**From:** Trevor Dixon  
**Sent:** 04 August 2020 08:01  
**To:** Rebekah Morgan  
**Cc:** Alex Keen  
**Subject:** 16/00472/OUT - S Grundon Services Ltd

I have reviewed the relevant reports again (let me know if I have missed anything) and my comments are as follows:

Figure 3 - Location of mitigation measures

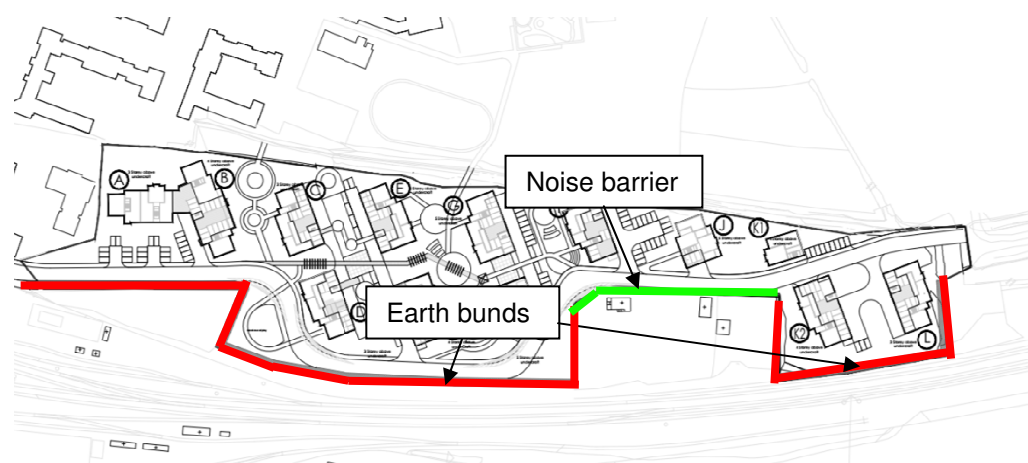
External daytime levels at a height of 1.5 metres are mostly within the desirable level of 50dB or the upper level of 55dB with a 6 meter barrier (bund and/or acoustic fence) in place. However, the barrier will only be effective at mitigating low level noise sources for example wheel noise on the rails that are close to the barrier, and protect ground floor dwellings and amenity areas. For diesel locomotives running on full power where the source height is 4 metres and sources further from the barrier such as the LMD, the barrier will offer less protection and no protection to the upper storeys. Also, the rail line is approximately 1.5 metres higher than the site towards the south east end of the site and it is not clear if this been accounted for in the barrier calculations.
